TOWN OF MONUMENT - WATERLINE AND STORAGE TANK
 SITE DEVELOPMENT PLANS
 LOT 6, FOREST VIEW ESTATES FILING NO. 4

2.0 MG WATER STORAGE TANK

90% SUBMITTAL

TANK PROFILE
SCALE: 1" = 10'

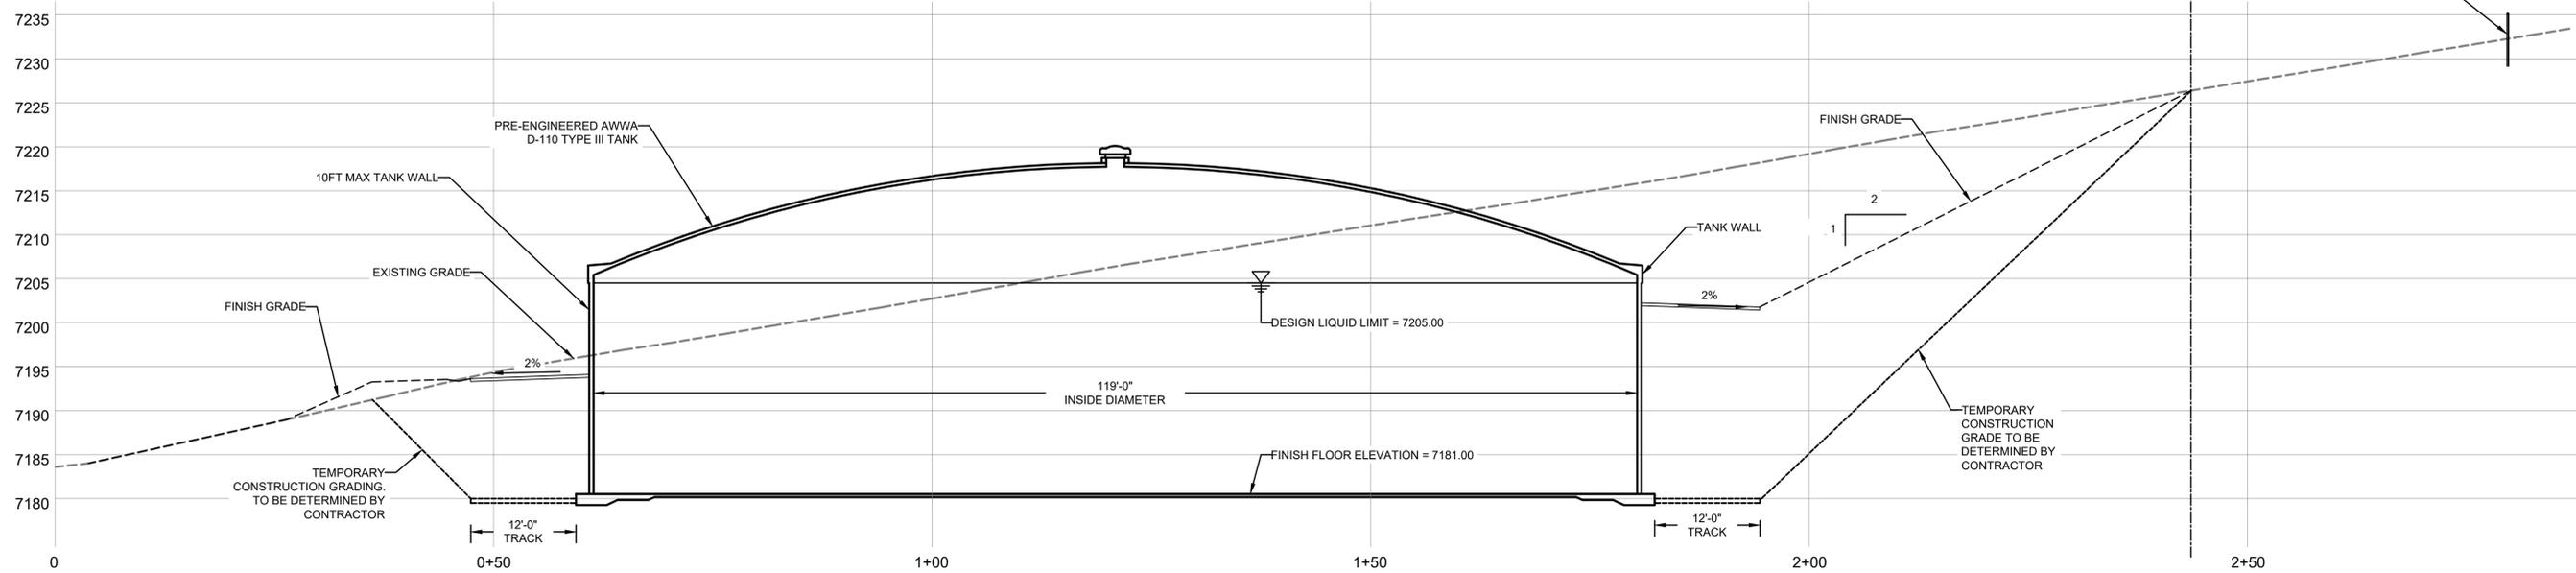
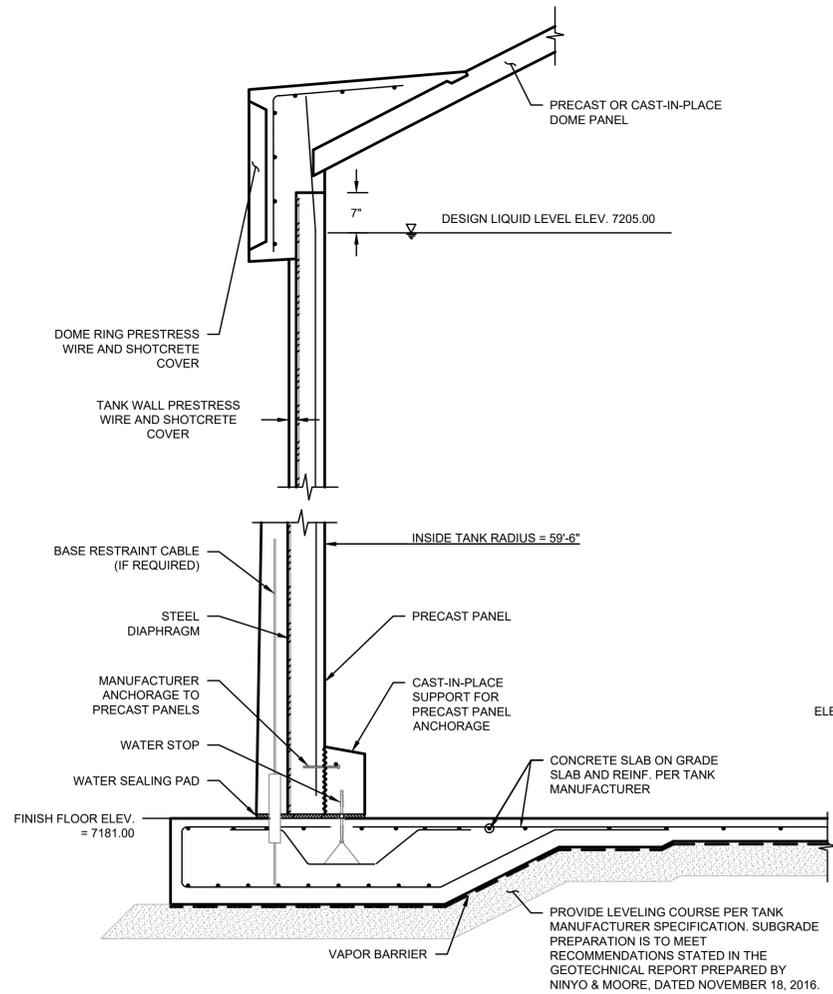
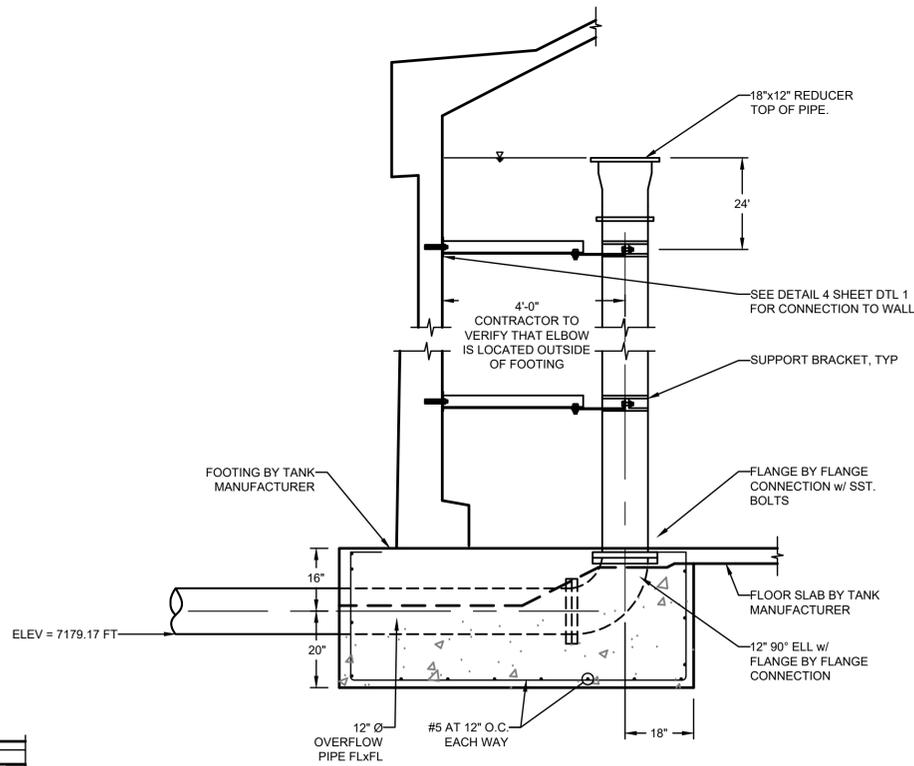
Add circumference and total gallon storage

LIGHT POLE FOUNDATION DETAIL

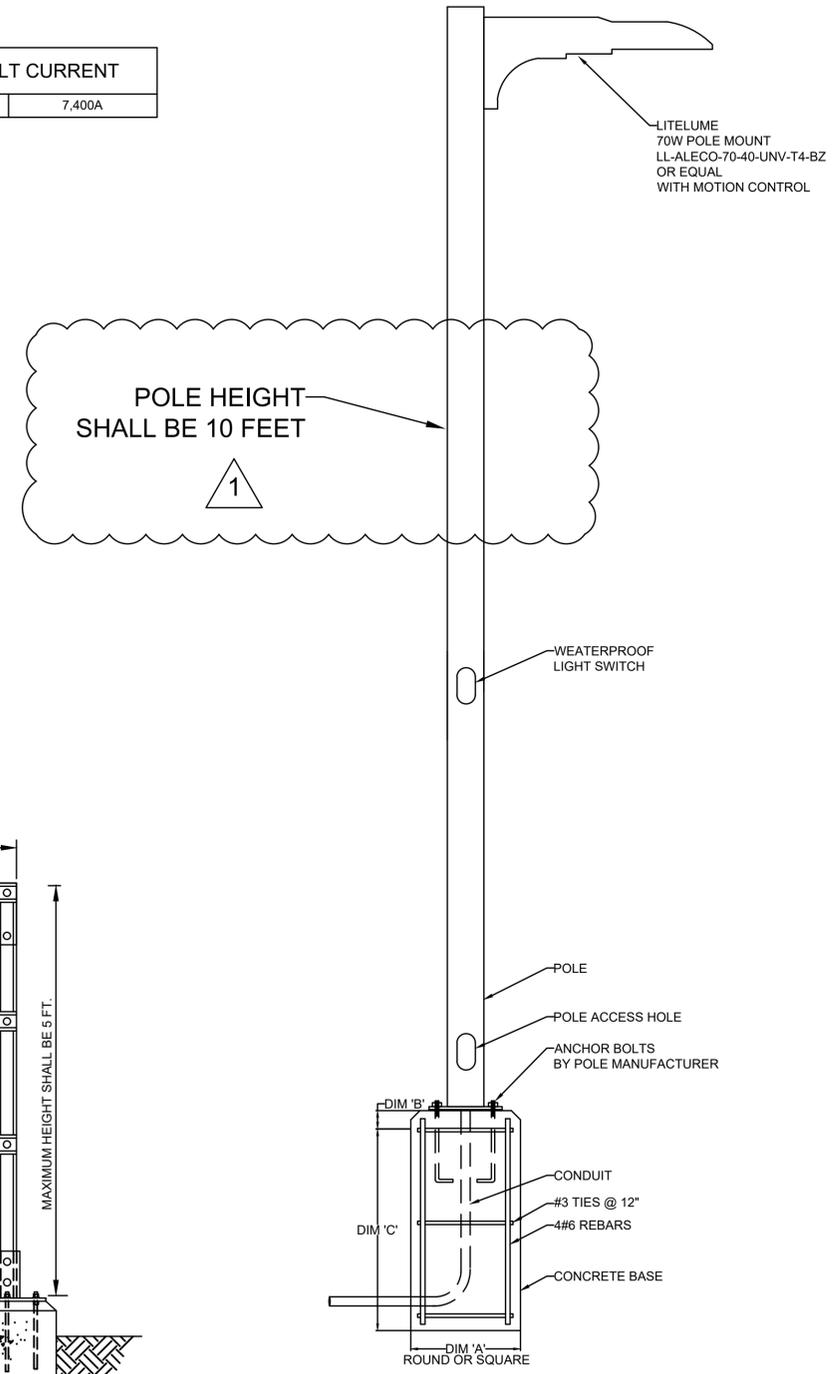
Add note that lumens will not exceed Max (based on Code)

is there only one light on entire project? If not add locations and detail of fixture

This exceeds the lighting standards; revise per Code above (Chapter 6). Please provide the exact detail for the fixture and pole- This is very industrial in nature; this is a residential zone district;

TANK SITE PLAN
SCALE: 1"= 20'

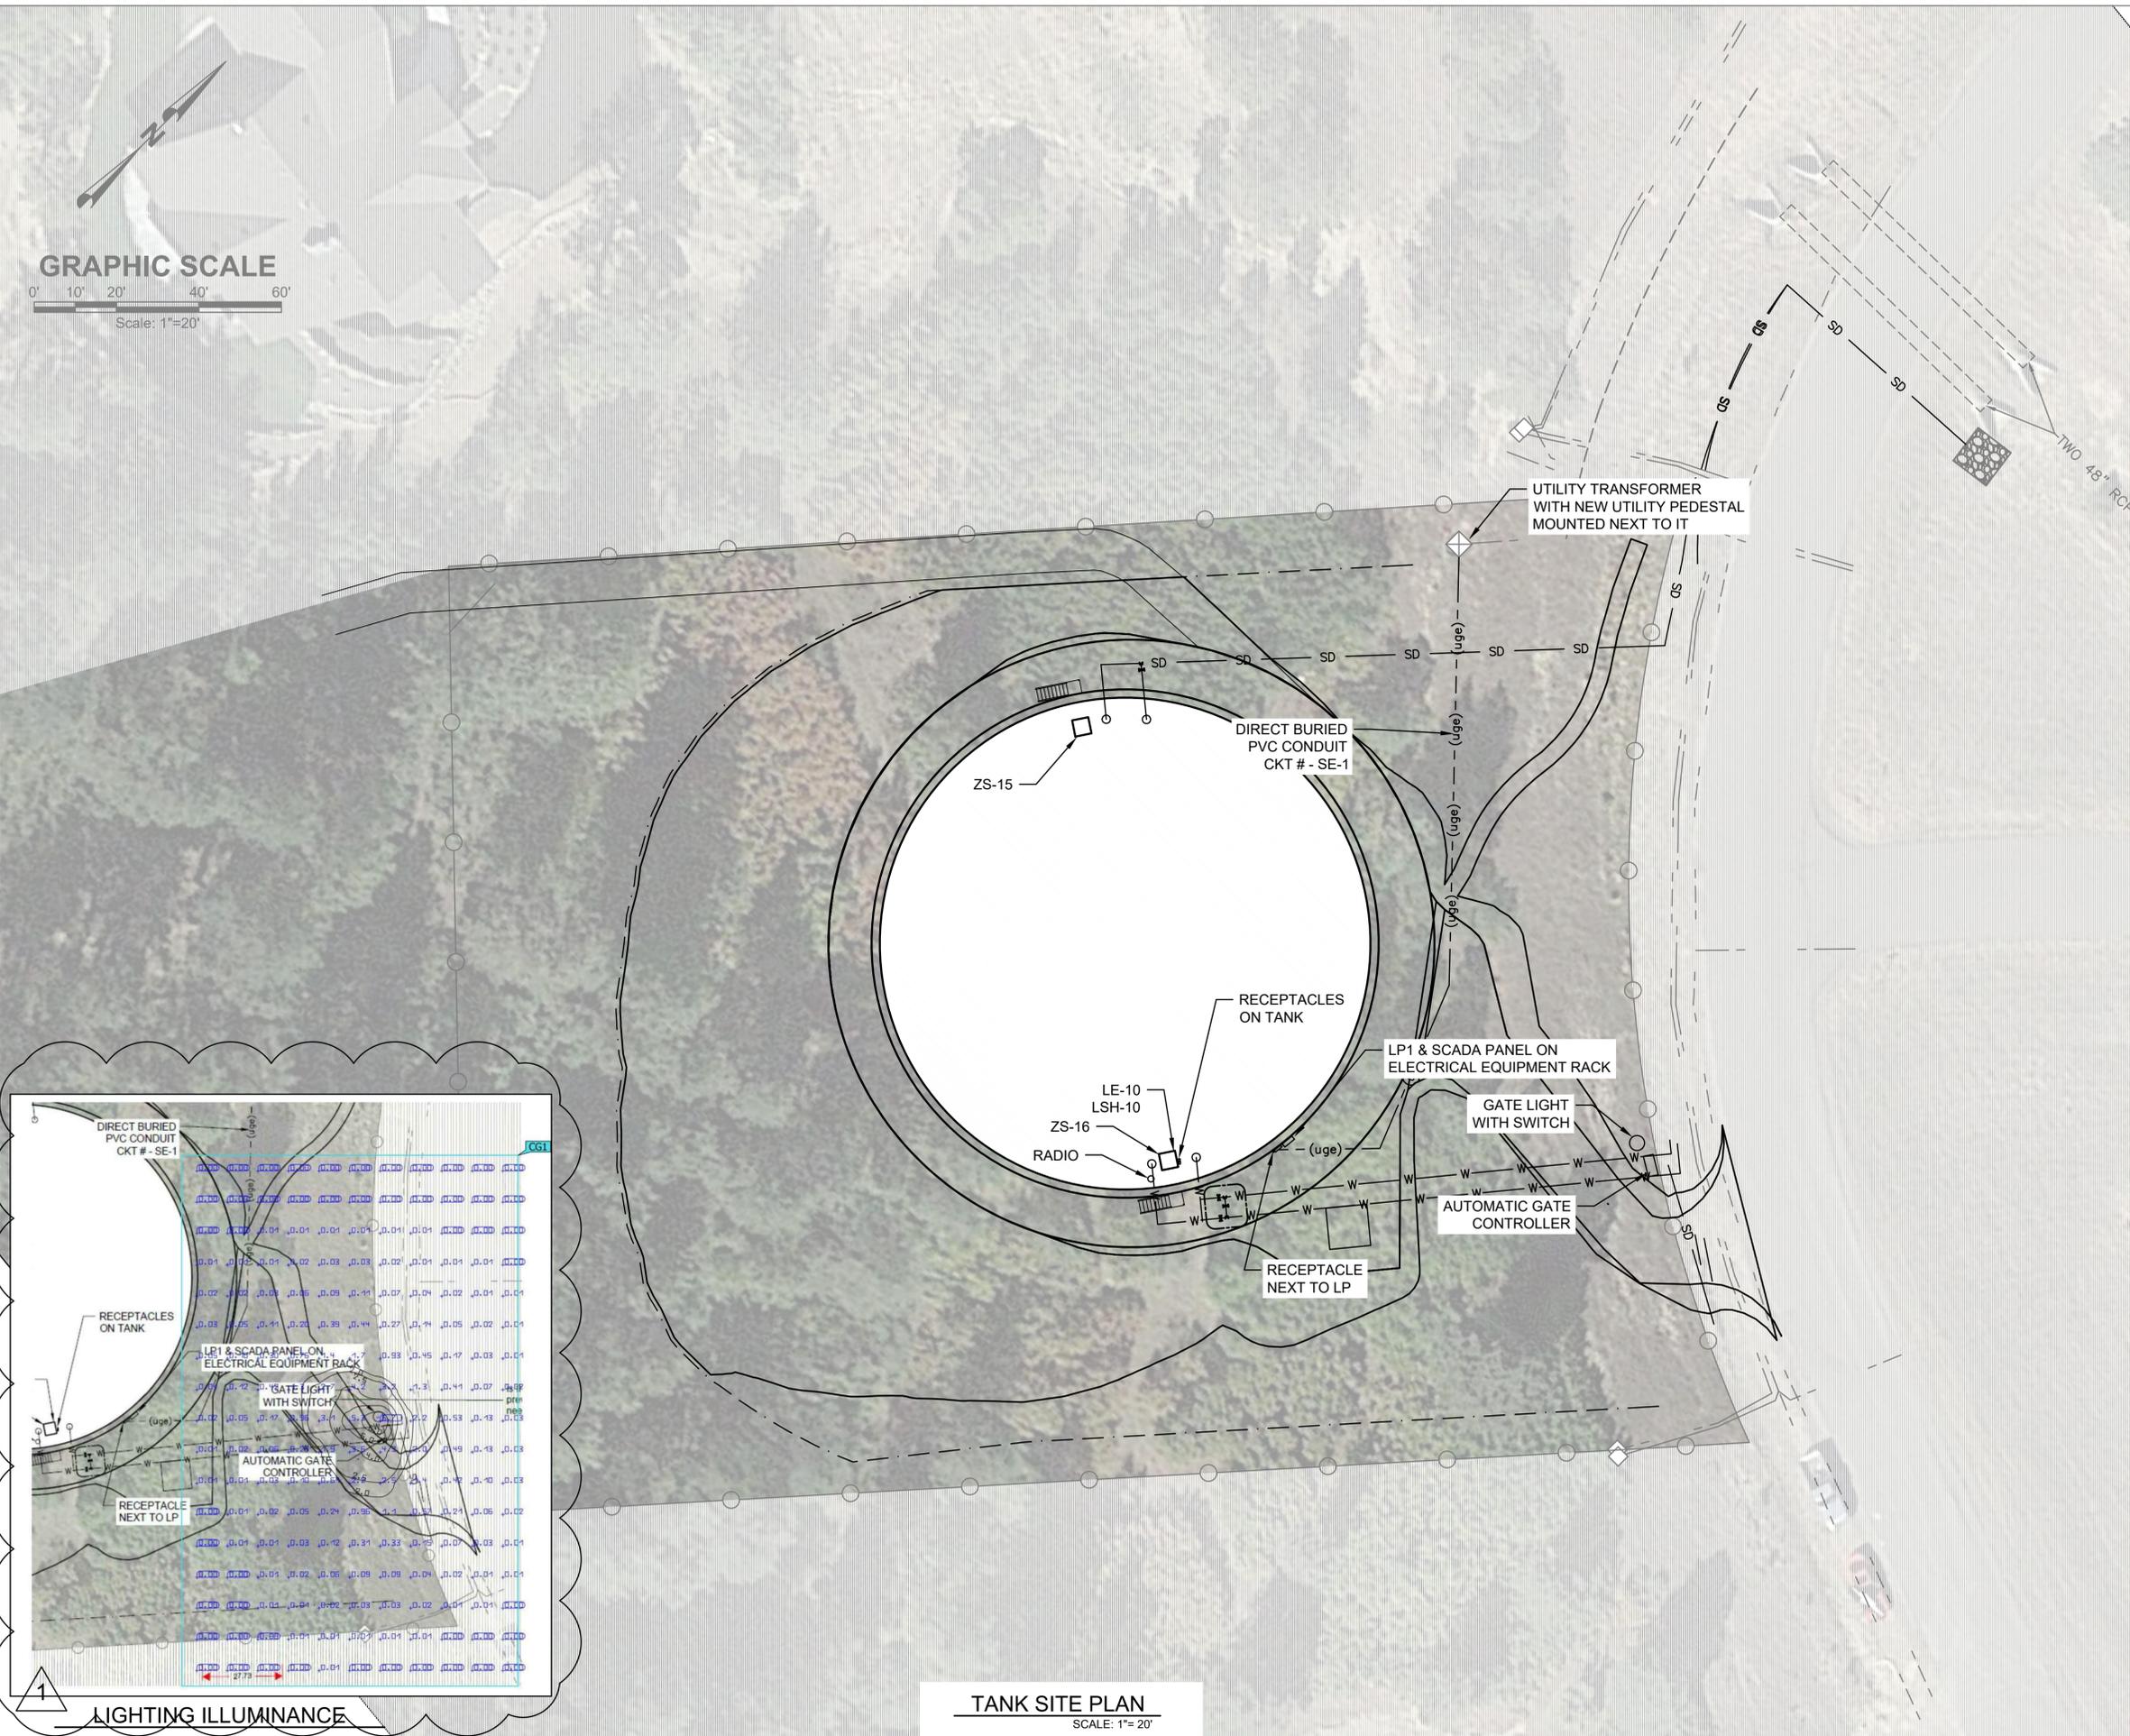
locate light fixtures on this sheet as well as sheet 2

Provide the detail of the chain link fencing, and the alternative fencing.

is the detail on the previous sheet that needs to be revised?
